Molly McGuire  
Mercer Island Community Planning and Development Department  
RE: Clarifications on Building Permit 2207-019 SUB4  
June 28, 2023

I am writing in response to two letters submitted as Building Permit 2207-019 SUB4.

MERCER RESIDENCE
6950 SE MAKER ST MERCER ISLAND, WA

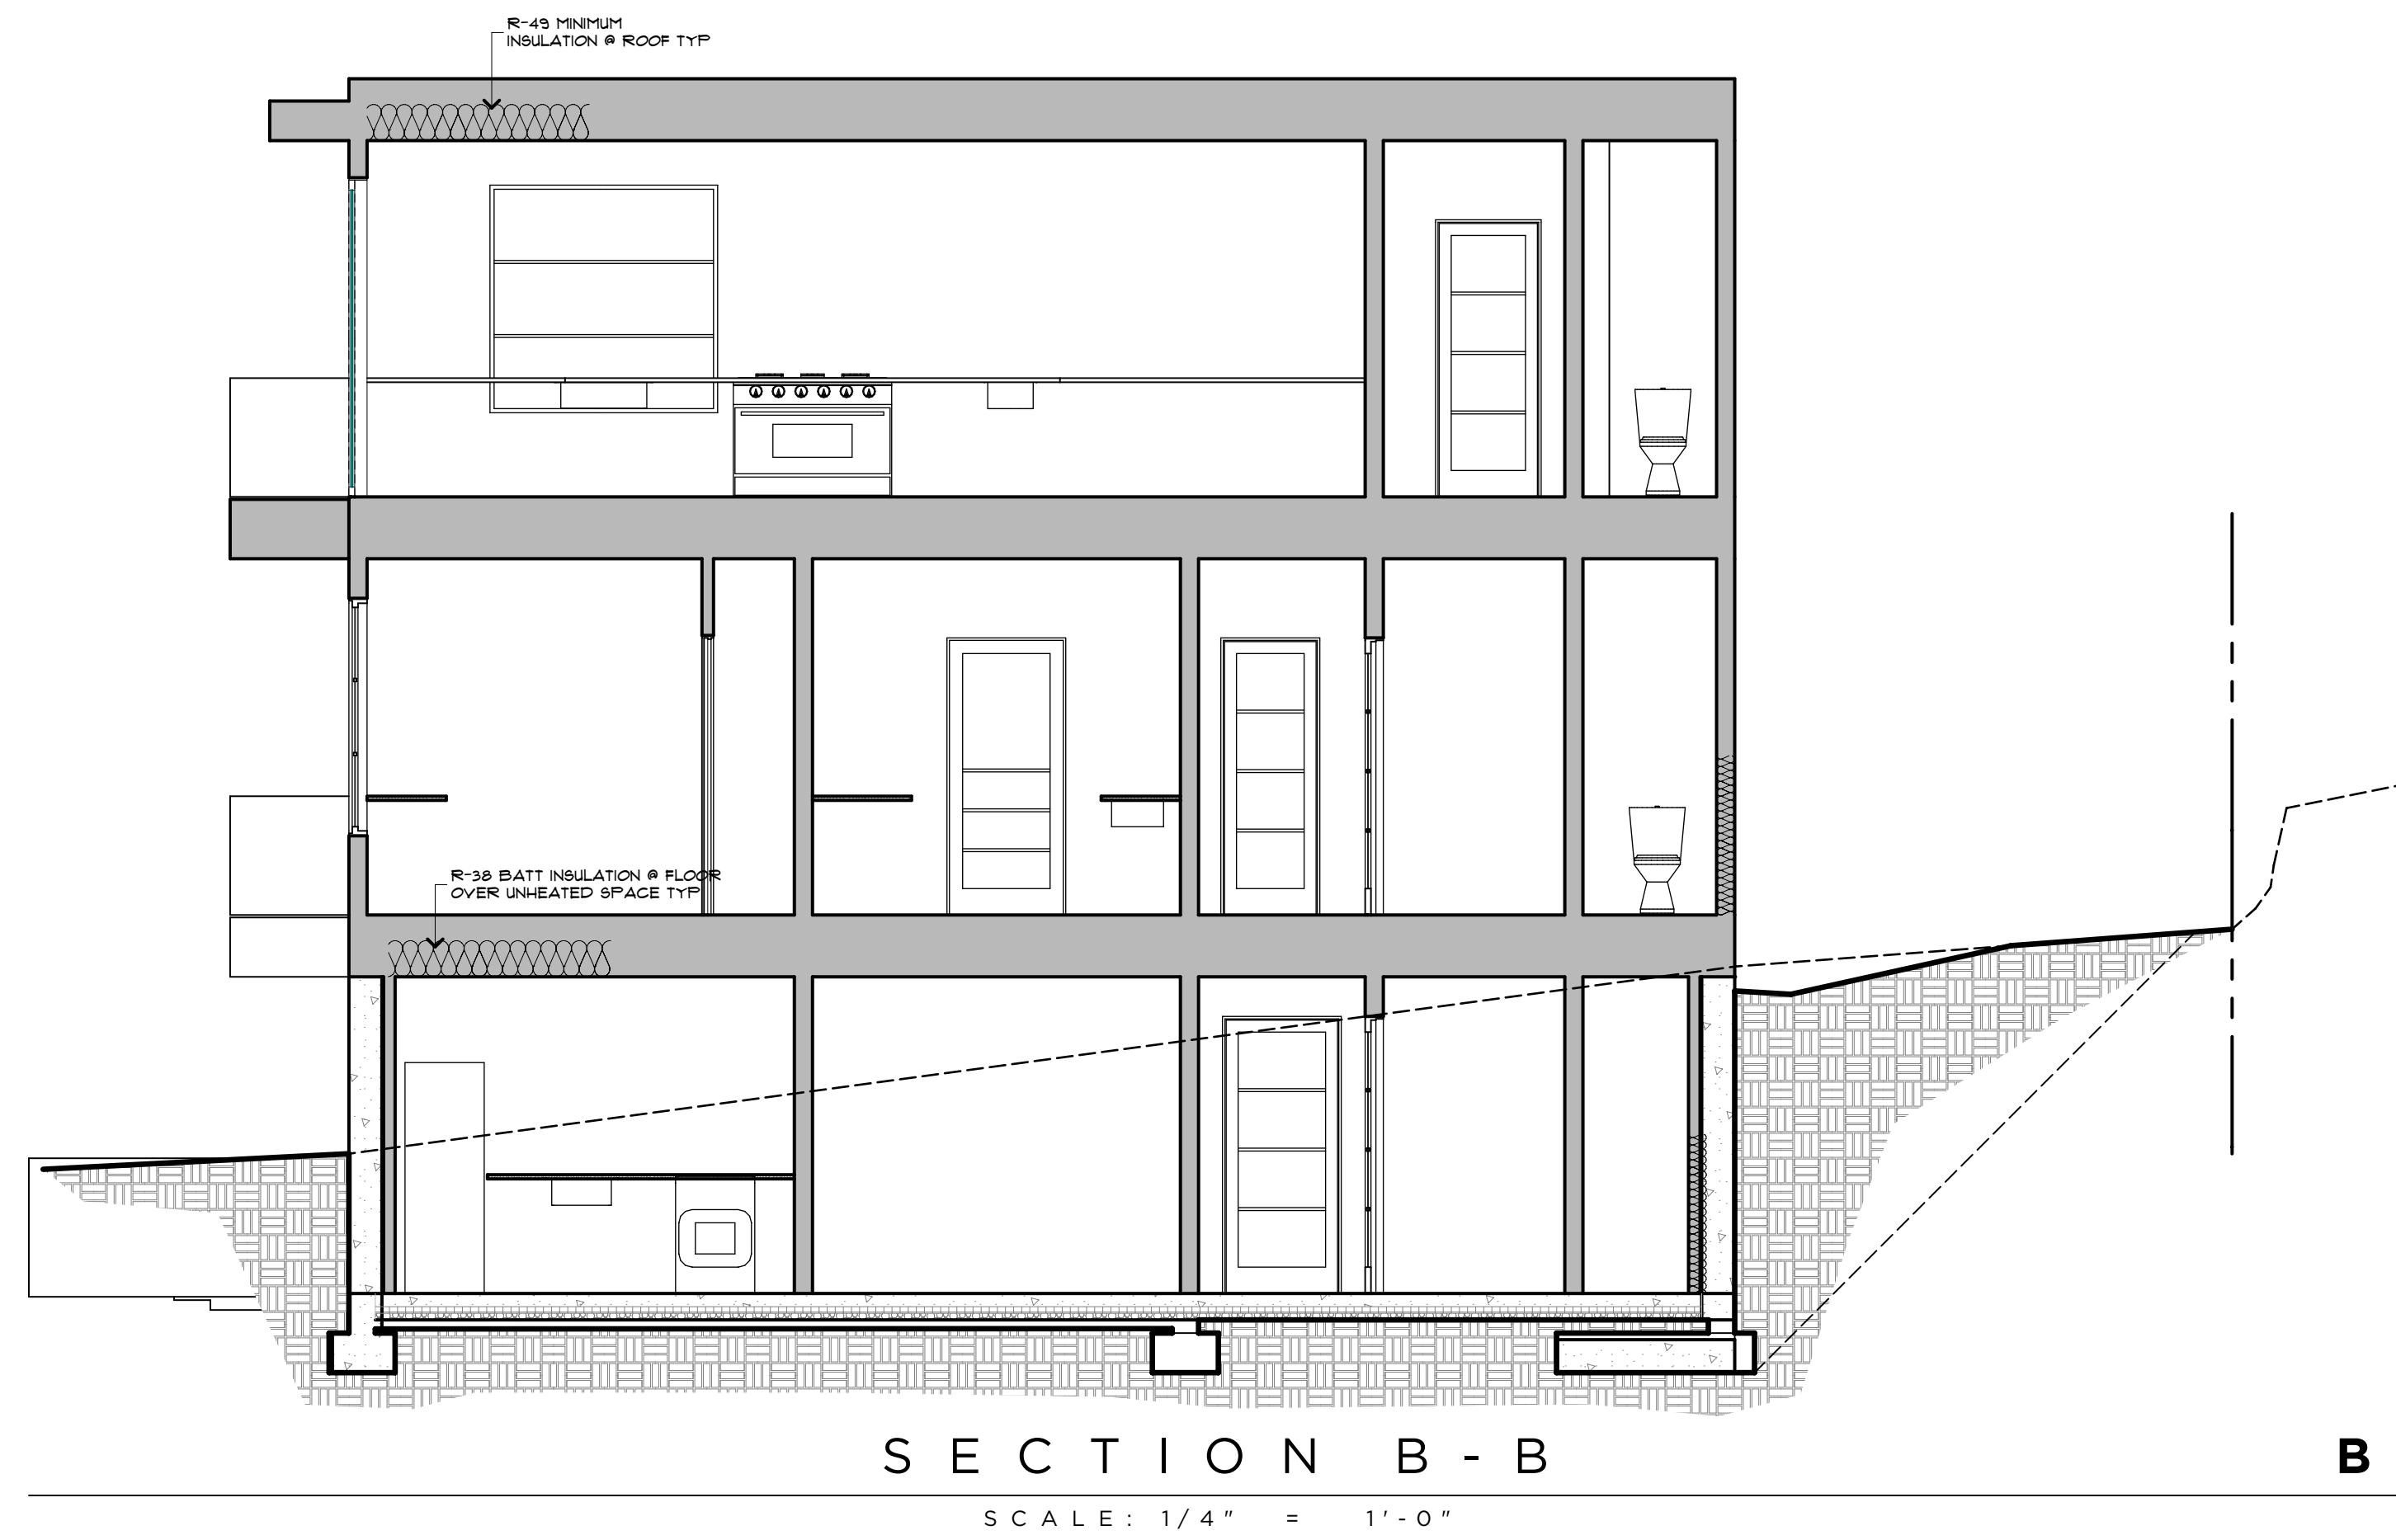
Finally, none of the submissions made to date have acknowledged that the northeast portion of the proposed structure sits on a walk-out basement slab at a grade of 228', shown below.
